### **Wylfa Newydd DCO Examination EN010007 - Deadline 10 Submission**

IACC has reviewed Horizon's Deadline 9 submission and has the following comments:

Scale	AS SHOWN	Sheet Size	A1	Sheet(s)	1 of 1
Drawing Number	WN0902-HZDCO-OHW-DRG-00063				Rev
				2.0

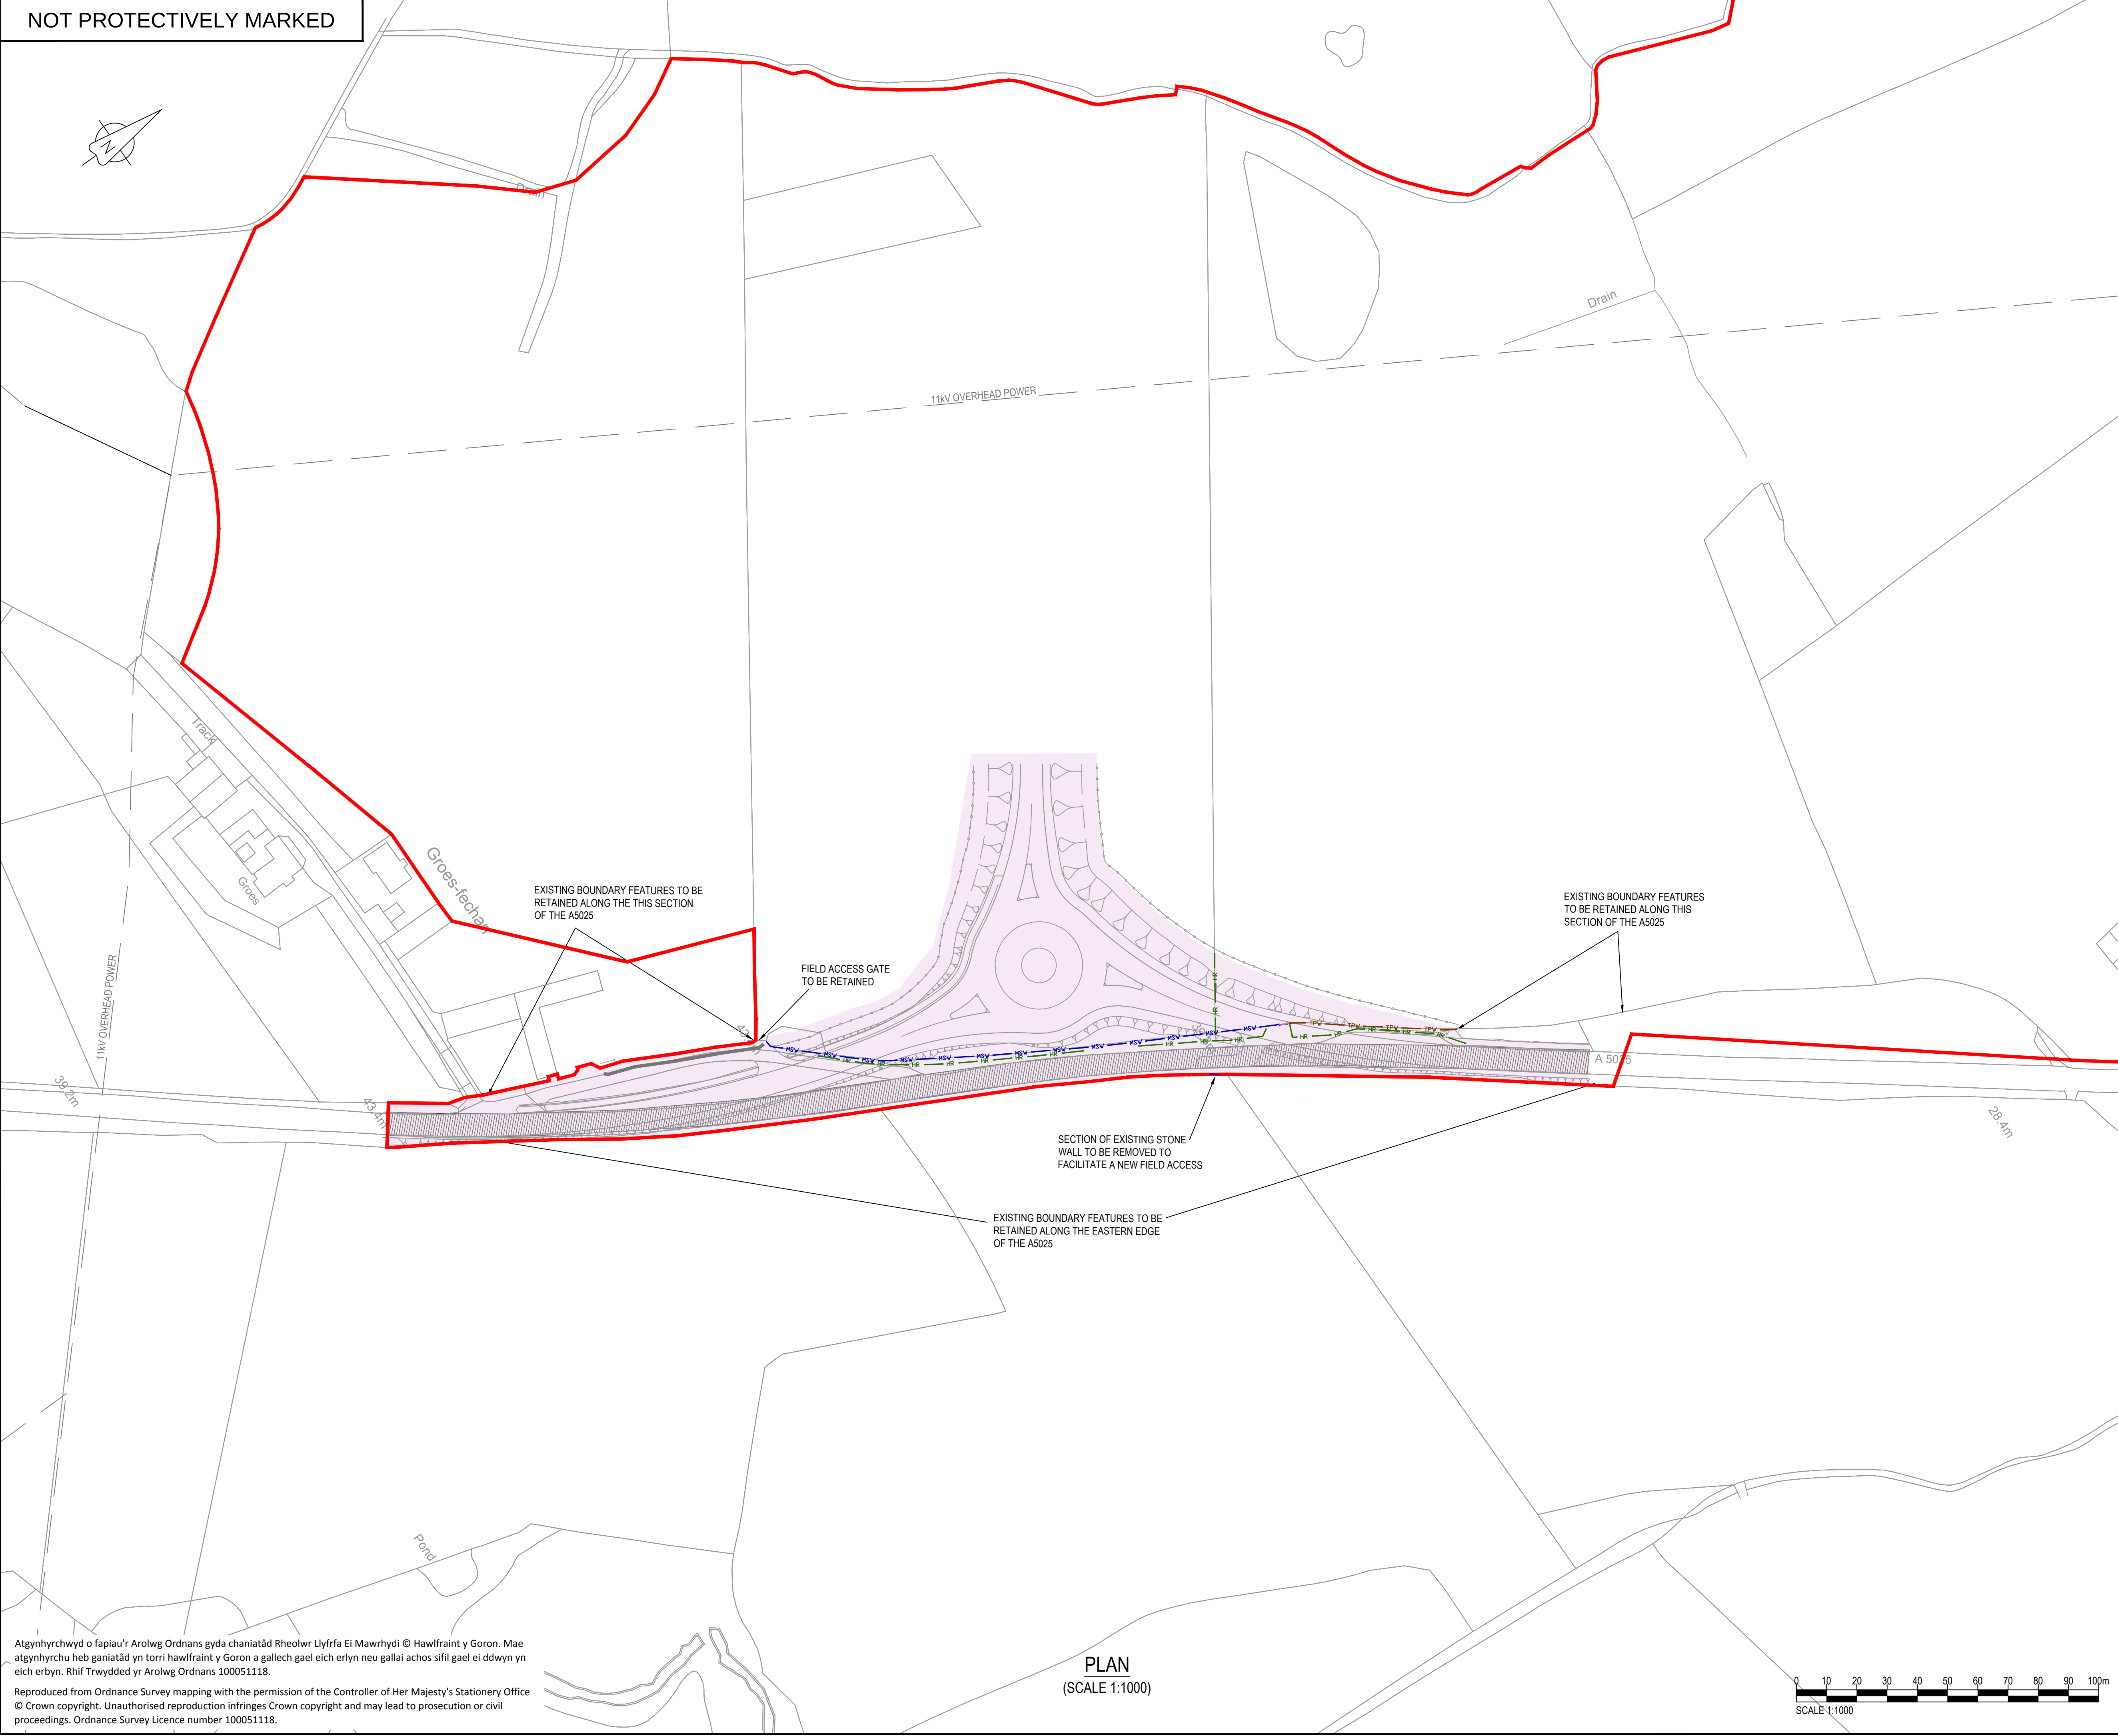
As a direct consequence of implementing the WNDA junction access arrangement, the existing vehicular turning area will be lost. Horizon's General Arrangement plan WN0902-HZDCO-OHW-DRG-00063 Revision 4.0 (2.6.1 WNDA – Power Station Site Plans) indicates the southern junction of the layby will be in use, thus avoiding the need to re-provide a vehicle turning area. Currently, due to the existing poor visibility at the southern junction, raised granite block paving has been laid to deter vehicles from using this junction (shown below). The IACC would deem it inappropriate, in the interest of road safety, to provide a junction at this location.

To mitigate for the loss of the existing vehicle turning head, the IACC seeks the provision of a new (alternative) vehicle turning head area adjacent the existing layby as part of the WNDA junction access arrangement works (whereby HNP are in agreement). The proposed location of the new vehicle turning area is within HNP land ownership and is within the red line boundary. The IACC see no alternative solution to re-providing a turning head area to what is proposed (as previously agreed between both parties).

As per the IACC's REP9-031 submission, to enable this proposed turning head area to be dedicated as a public highway, the purple dashed line (centreline of proposed highway) would require extending on the Right of Way Plan (**REP8-024** page 33).

To secure this proposed turning head area as part of the DCO process, the relevant plans including A5025 Off Line Highway Improvements Section 9 – Power Station Access Road Junction Proposed General Alignment WN0902-HZDCO-OHW-DRG-00063 Revision 4.0 (2.6.1 WNDA – Power Station Site Plans) (**REP8-027**) and A5025 Off-line Highway Improvements Section 9 – Power Station Access Road Junction Right of Way WN0902-HZDCO-ROW-DRG-00030 (2.4 Right of Way Plans Revision 3.0) (**REP8-024**) must be revised accordingly to accommodate this proposal in order to allow the DCO to consent this approval.

HNP have advised that there is not sufficient time to amend the drawings which would be affected by this change and that this turning area can be included in the design approved at the detailed design stage. The IACC has concerns as this will not be a DCO Requirement and therefore is not secured within the DCO.

The IACC understands that changing drawings to include this turning head would be difficult at this stage however, in order to secure the re-provision, the IACC requests that requirement WN1(3) is amended by addition of a new item (h) requiring a scheme to be submitted for approval as follows:

(h) A scheme for the provision of a vehicle turning head which will form part of the public highway at the layby adjacent to access to the WNDA, which scheme must include the details of the design of the turning head, details of when this will be delivered, together with an explanation of how this will be dedicated as public highway, how it will be classified and what traffic regulation measures (including any applicable speed limits or waiting restrictions) will be put in place over the turning head prior to it opening for use for by the public.
